Heckington Fen Solar Park

Statement of Common Ground with Environment Agency

Applicant: Ecotricity (Heck Fen Solar) Limited

Document Reference: 7.6d

Drawing file: EN010123 / EN010123-000760-6.2.4 - Figure 4.22 - Substation Control Building - Rev 2.pdf

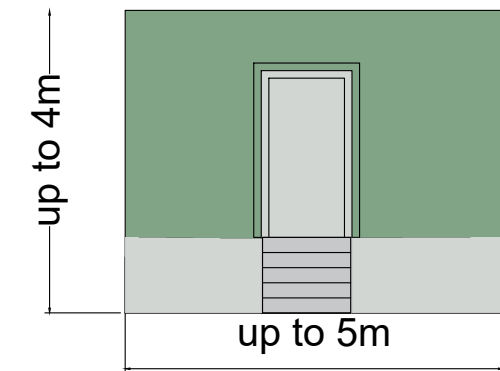
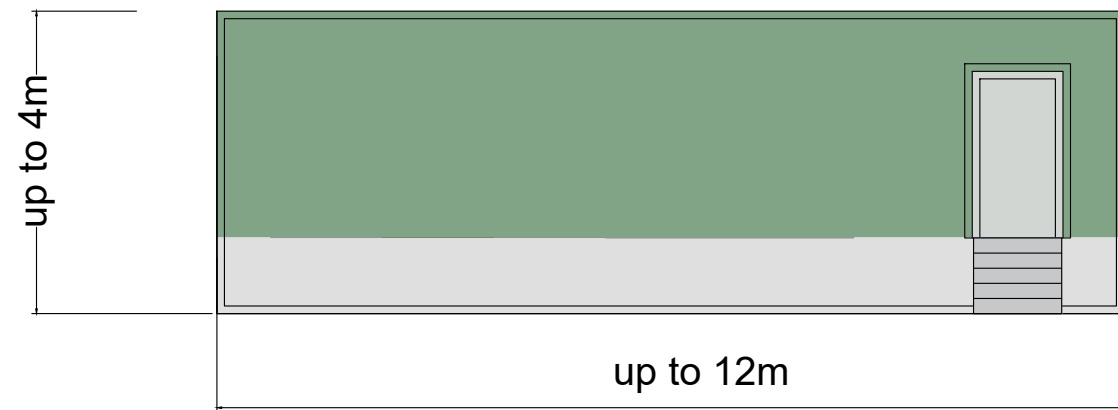
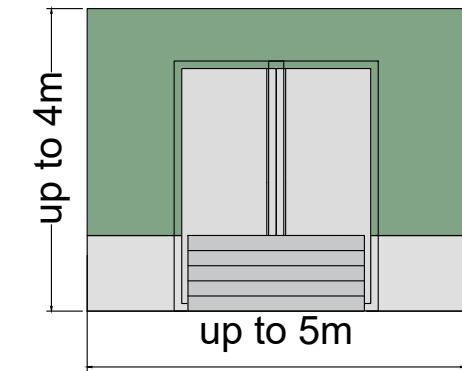
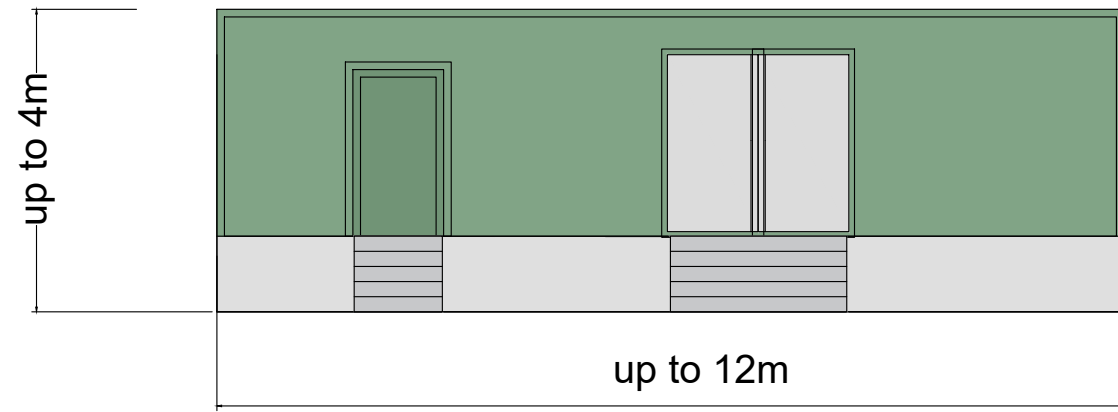
Reference and Status	Topic	EA's Position	Applicant's Position
		<p>authorities). The FRA is appropriate to the scale, nature and location of the development from a fluvial perspective. However, we request clarity in respect of the flood risk mitigation design levels quoted in paragraph 9.1.3 ([AS-020]. This paragraph appears to be stating that "The solar panels and other flood-sensitive infrastructure (transformers, energy storage modules, control rooms, etc) will therefore be elevated above the 1,000 year + 20% breach flood level of 1.95mAOD". However, it then goes on to state that only the 'other flood-sensitive infrastructure, such as transformers and energy storage modules, will be elevated above the breach flood level by localised ground raising and/or appropriate foundation design, with any sensitive equipment located at or above 2.25mAOD (1,000 year + 20% breach flood level of 1.95mAOD + 300mm freeboard).</p> <p>It is the EA's view that the finished floor level of the control rooms should be set at or above the 2.25mAOD level and we request confirmation that this is included as 'flood-sensitive infrastructure'.</p>

Reference and Status	Topic	EA’s Position	Applicant’s Position
1. Assessment of effects (including survey areas, baseline data and methodology) relating to Flood Risk and Drainage			
1.1. Under Discussion	Environmental Statement Chapter 9 – Hydrology, Hydrogeology, Flood Risk and Drainage Chapter 9 alongside Appendix 9.1: Flood Risk Assessment, Parts 1 and 2 (Rev 2)	The EA has reviewed the FRA from a fluvial perspective only (other sources of flooding such as groundwater, drainage systems, reservoirs, canals and ordinary watercourses fall under the remit of other flood risk management	The Applicant can confirm the finished floor level of the control room at the energy park site will be at or above 2.25mAOD. This could be added to the Outline Design Principles at the next revision.

6.2 Agreed	Requirement 6 (Detailed design approval)	EA are satisfied that flood risk mitigation is secured in the DCO at Schedule 2, Requirement 6(2), which ensures the detailed design must accord with the outline design principles in the FRA, subject to the confirmation being received regarding the setting of the finished floor level of the control rooms at or above 2.25mAOD (above Ordnance Datum).	The Applicant welcomes this confirmation and can confirm that the finished floor level of the Energy Park control room will be at or above 2.25mAOD. This could be added to the Outline Design Principles at the next revision.
